CITY OF ALBUQUERQUE

RE: **Matheson Park Elementary School Site Improvements** **H21-D036**
4410 Irving Blvd. NW PE Stamp: 4/22/2013
Grade & Drain Plan for Grading, Paving and SO-19 Permits

Based upon the information provided in your submittal received 05-16-2013, the above referenced plan cannot be approved for Grading, Paving or an SO-19 Permit.

SHEET
C-403

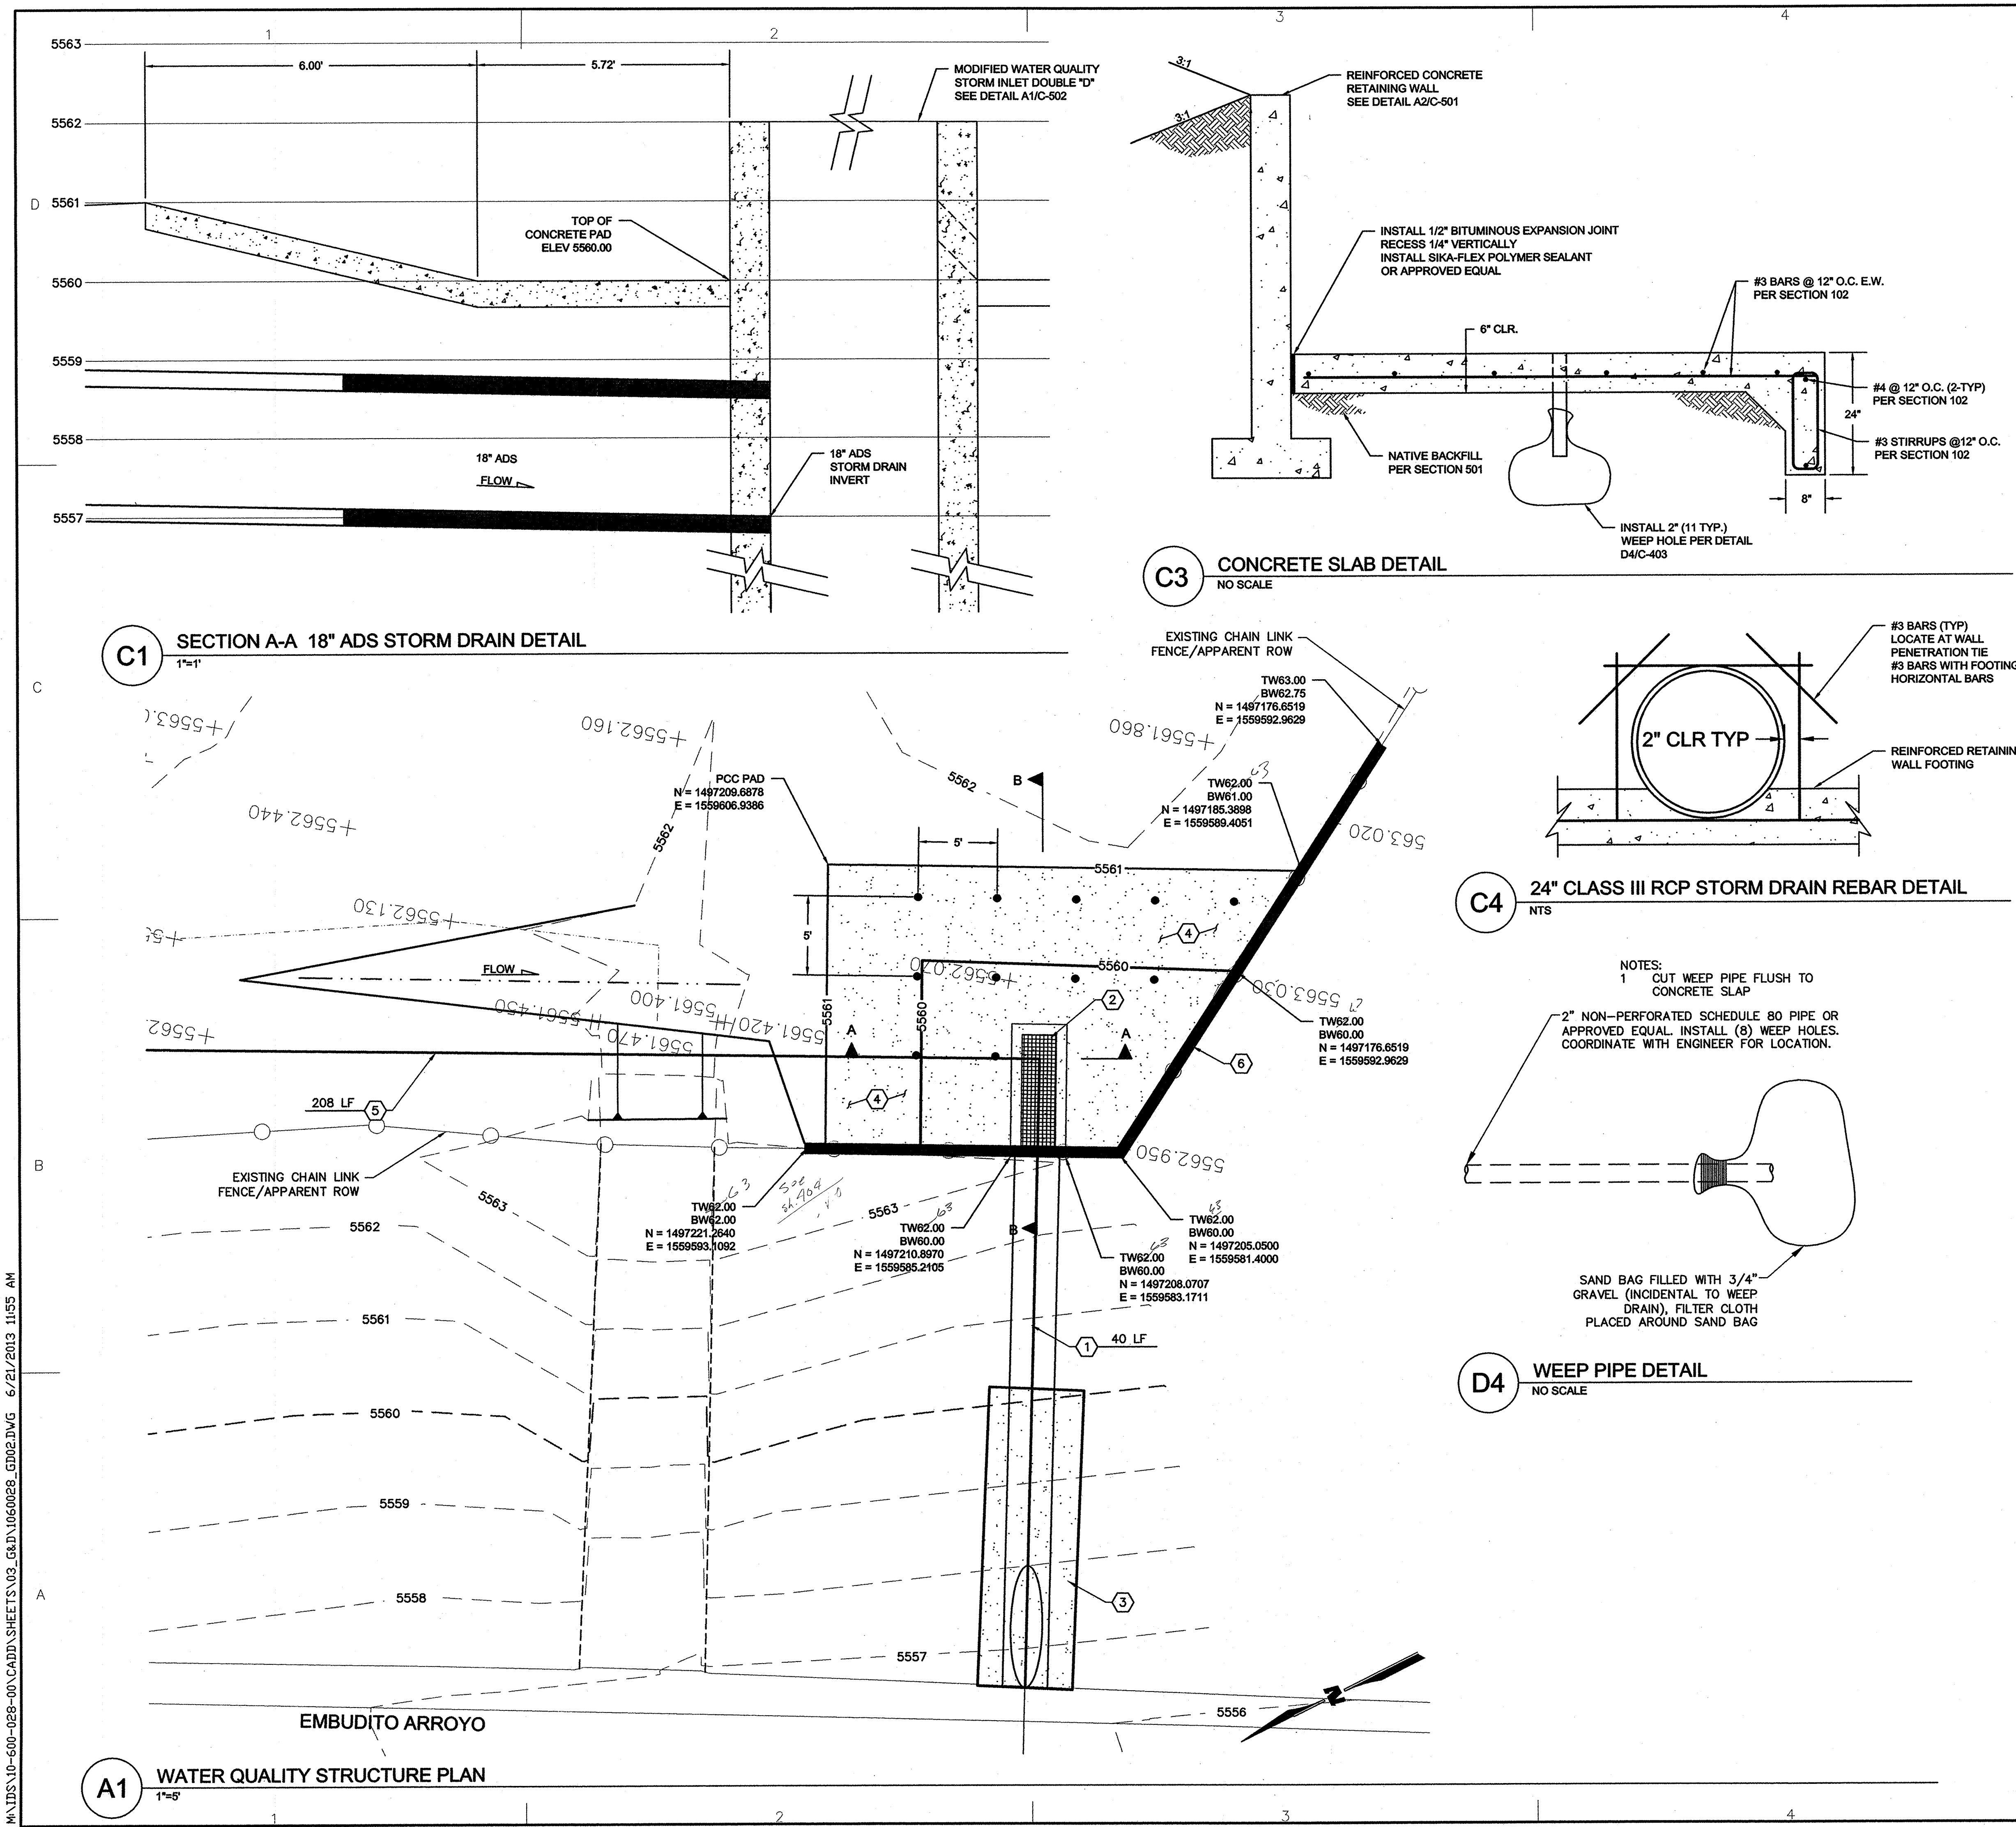
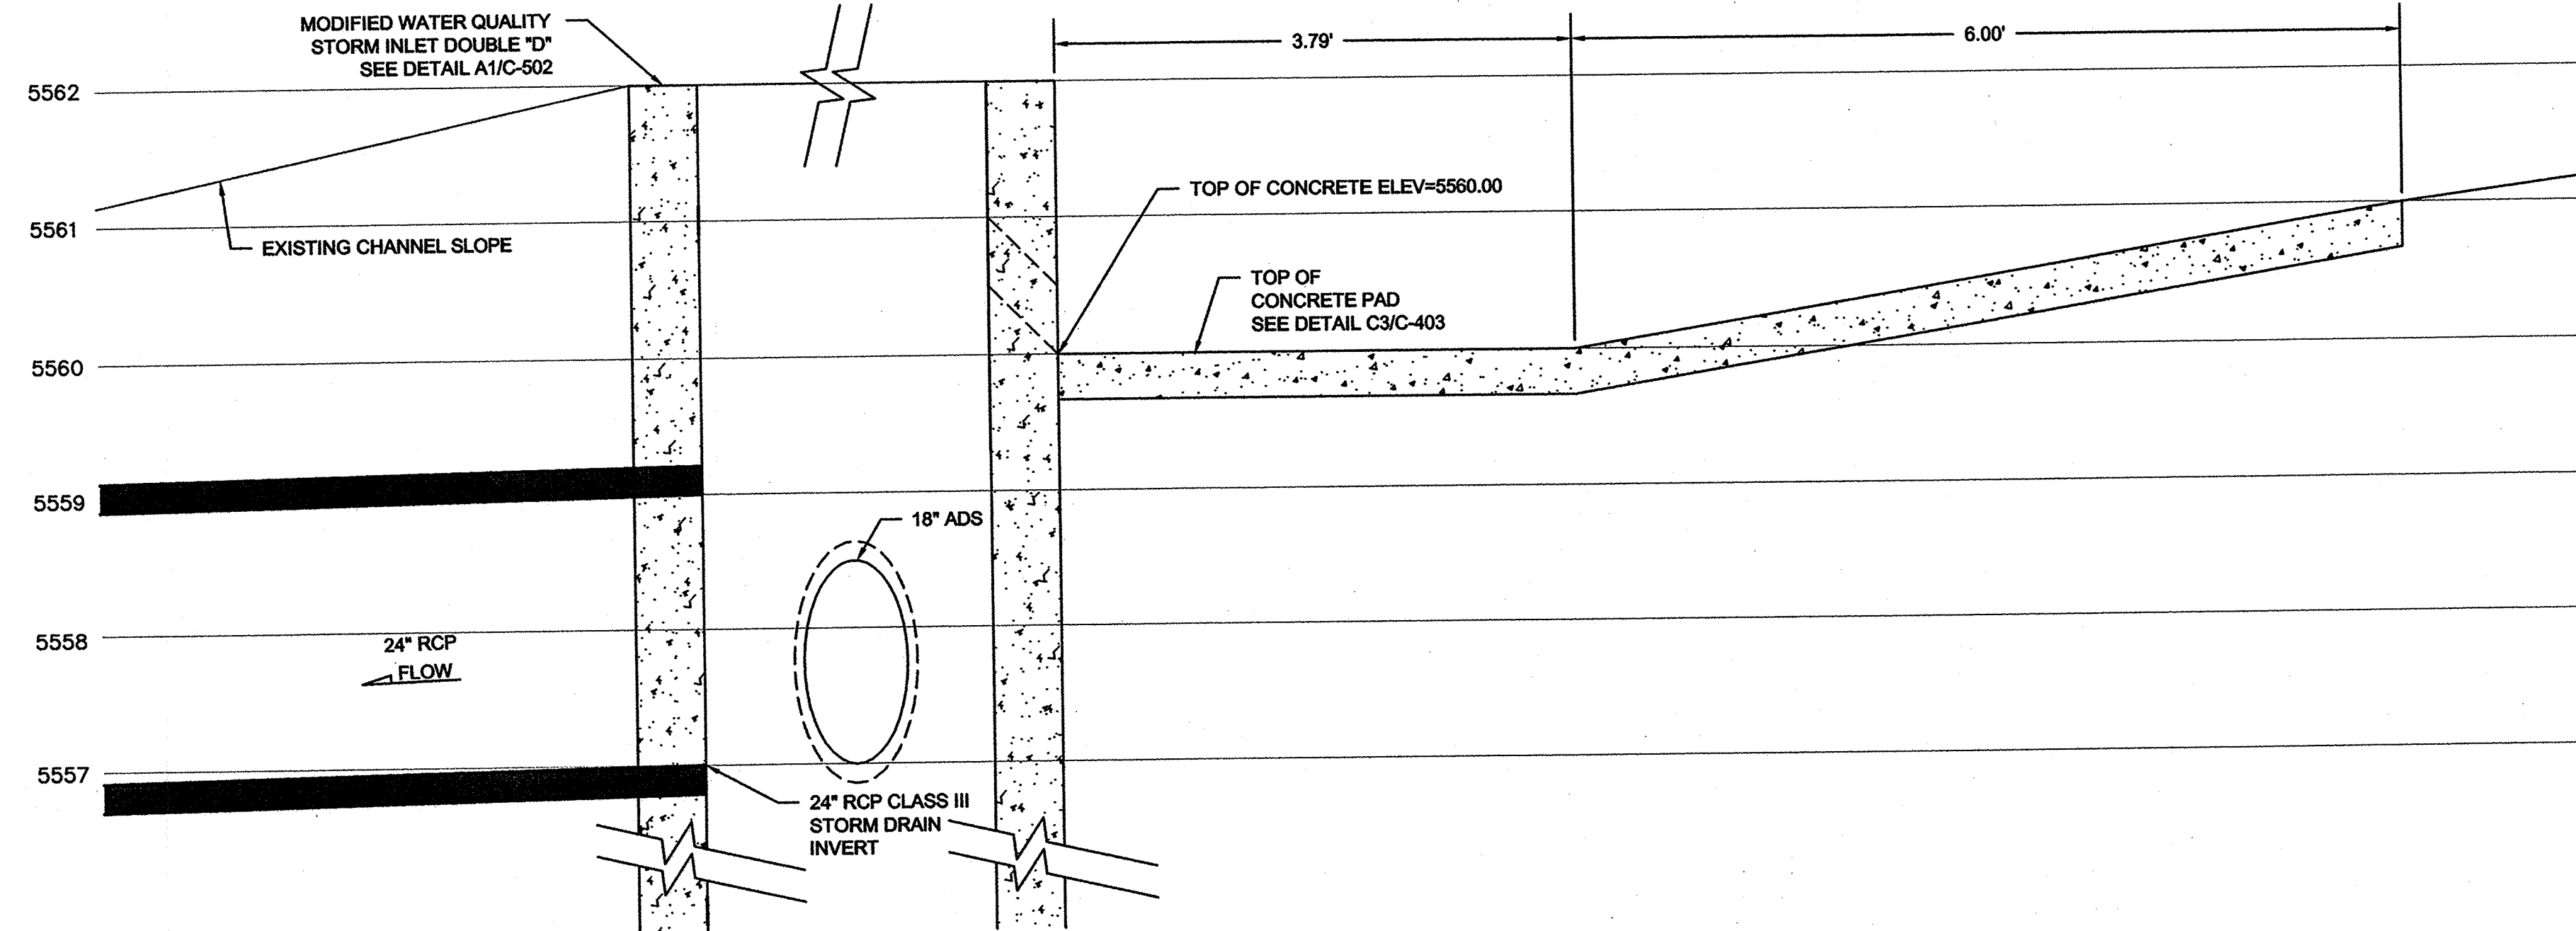
10. C-102: Provide a better description of the proposed desiltation facilities at the SW corner of the site, and a clear description of the SO-19, Private Drainage Facilities in Public R/W. Existing and proposed grades in the pond area are not legible at this scale. Clarify how the Water Quality Inlet will be positioned and function within this setting, and detail how the outfall pipe and existing rundown will be built.

11. C-102: The SO-19 notes need to include a signature line for the City Inspector, and may need to be moved, if the SO-19 details are described in an enlargement on another sheet.

A2 REINFORCED RETAINING WALL
SCALE: NTS

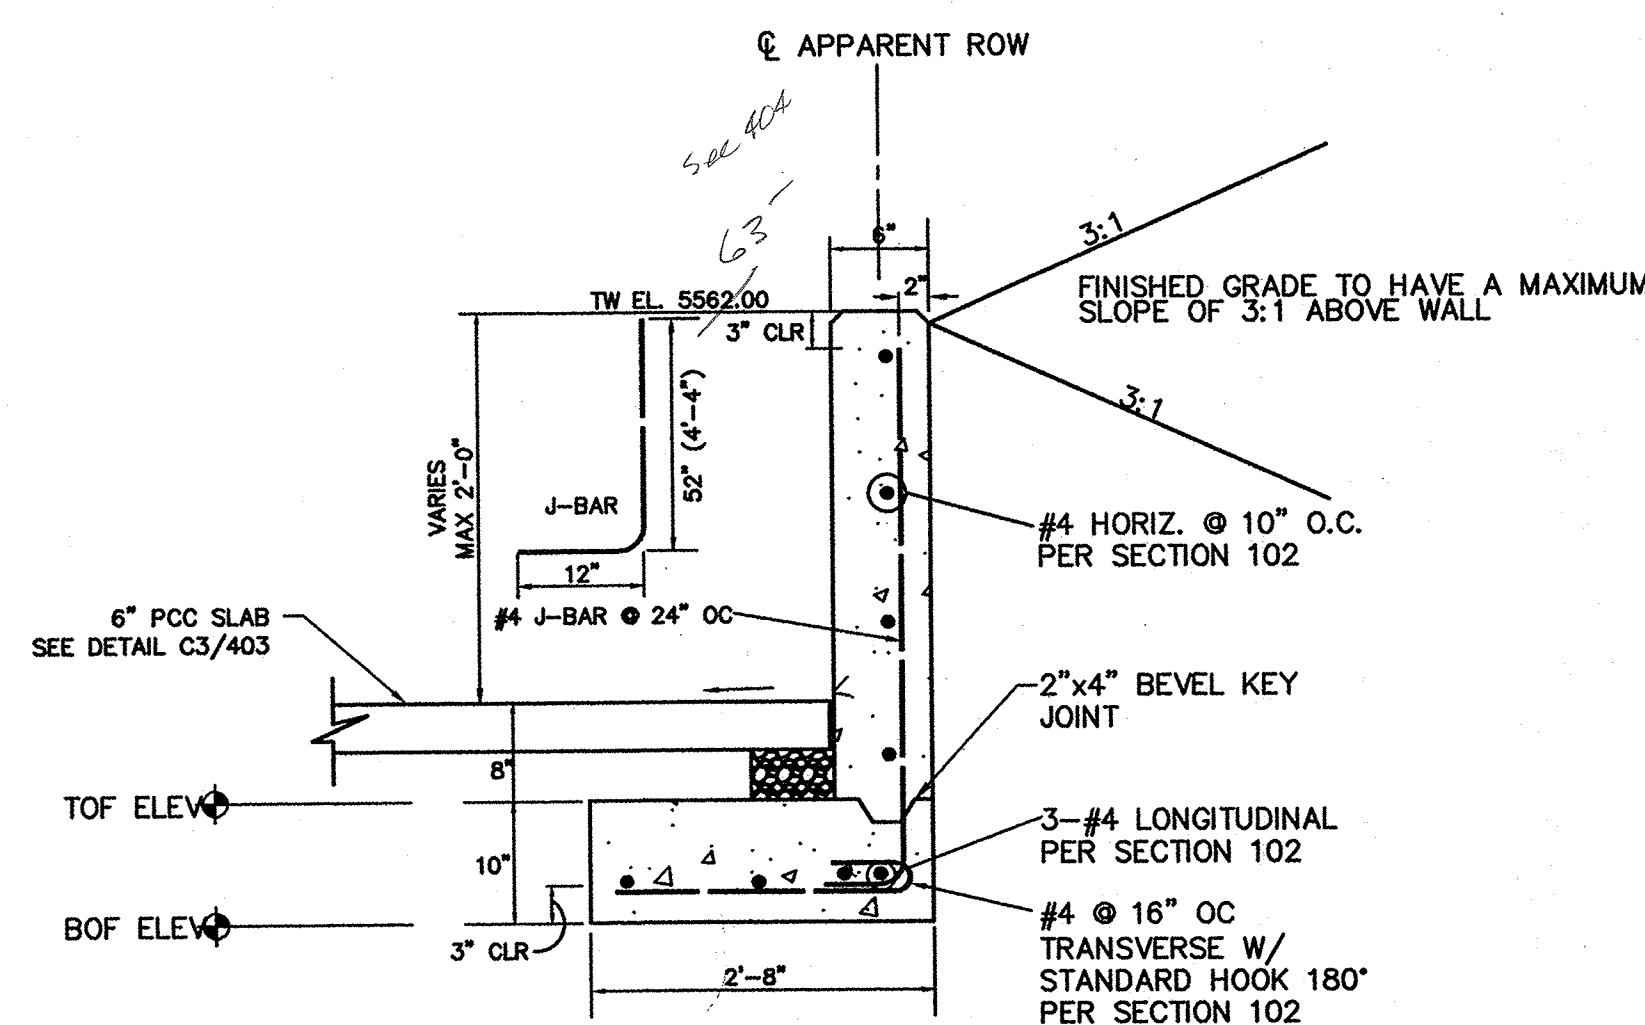
16. C-102: The plan near the SW corner apparently includes a retaining wall and conc. slab per Detail A2 on C-502. Show the limits of the retaining wall and provide top of wall and bottom of wall grades. Also, provide limits for the concrete slab, or include sheet 403, if that's more appropriate.

23. C-502: Detail A2 Retaining Wall seems to have the "L-type" wall footing and reinforcement reversed for reinforced conc. design strength; please verify. Also, show the relative position of the property line in this section and dimension wall offset.

24. C-502: Detail A2 shows a concrete slab, per Detail C3/403, which was not submitted.
25. C-502: Detail C3, Sections A-A and B-B need to show where the design grade is for the pond bottom, so that the Water Quality inlet tubes are exposed to flow.

A4 12" ADS INLET
SCALE: NTS

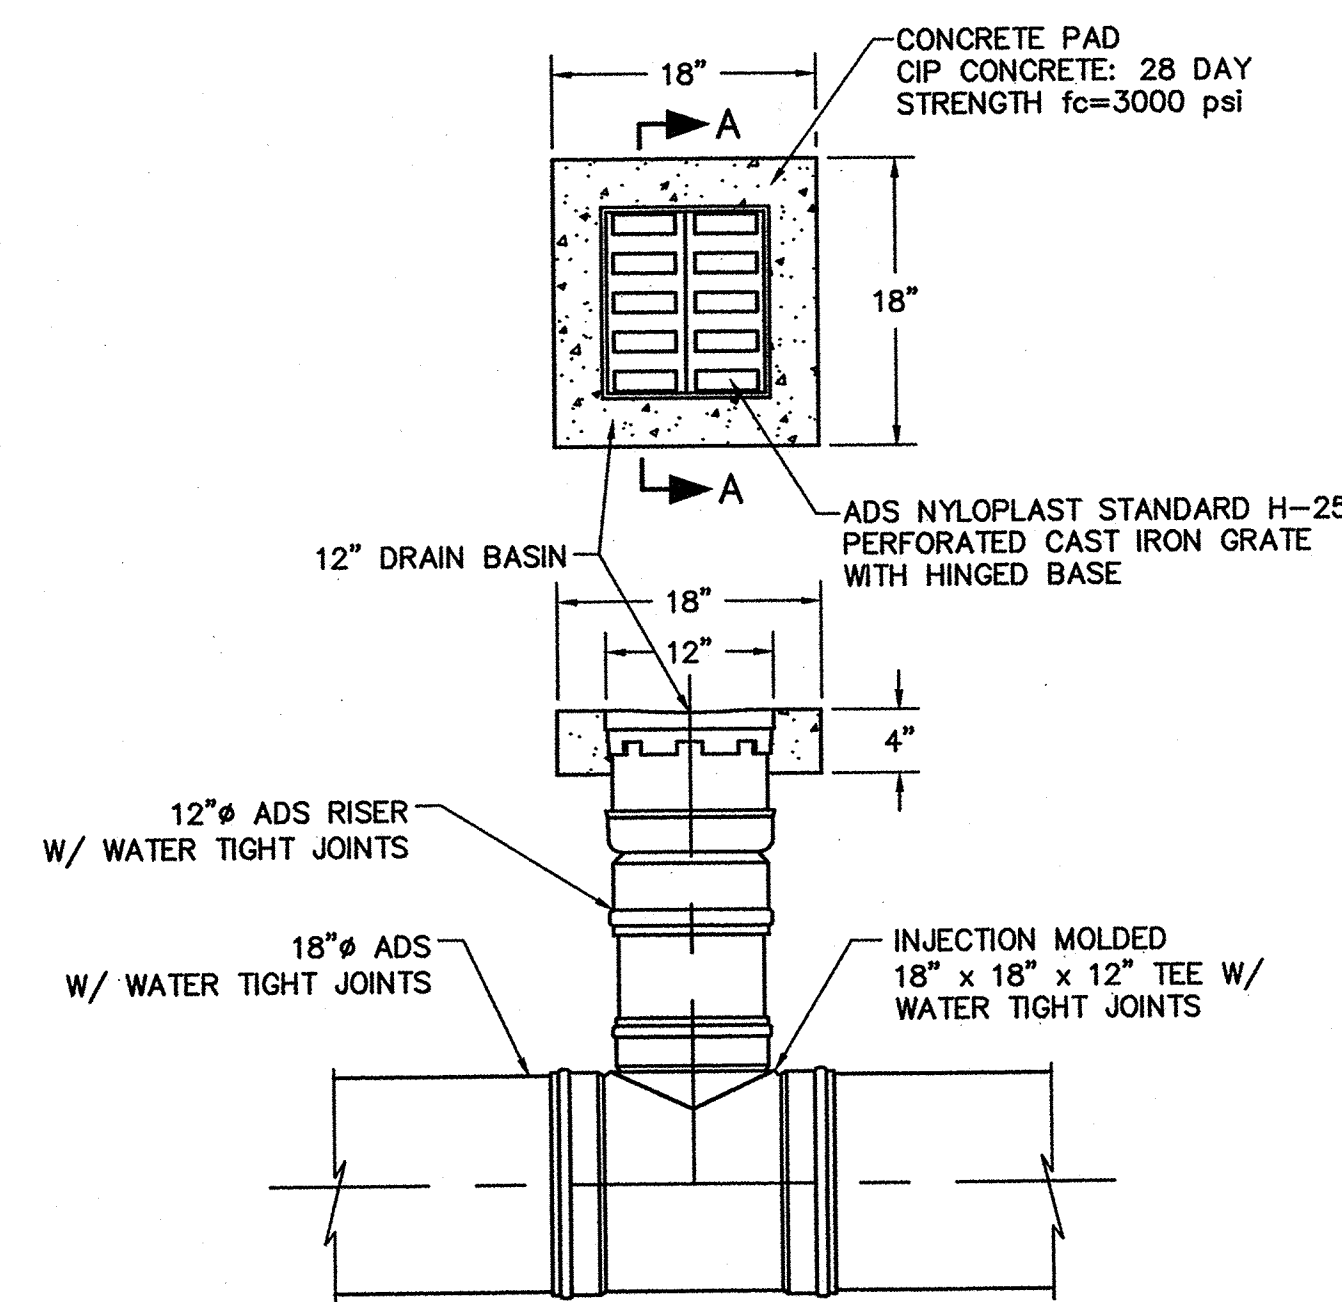
17. C-103: Label some of the contour lines on the enlarged plans for clarity.
18. C-501: Detail A4 shows the main line to be 18" SDR-35 PVC, which differs from the ADS called out on C-102. Also, this detail does not provide a spec for the 12" riser pipe.
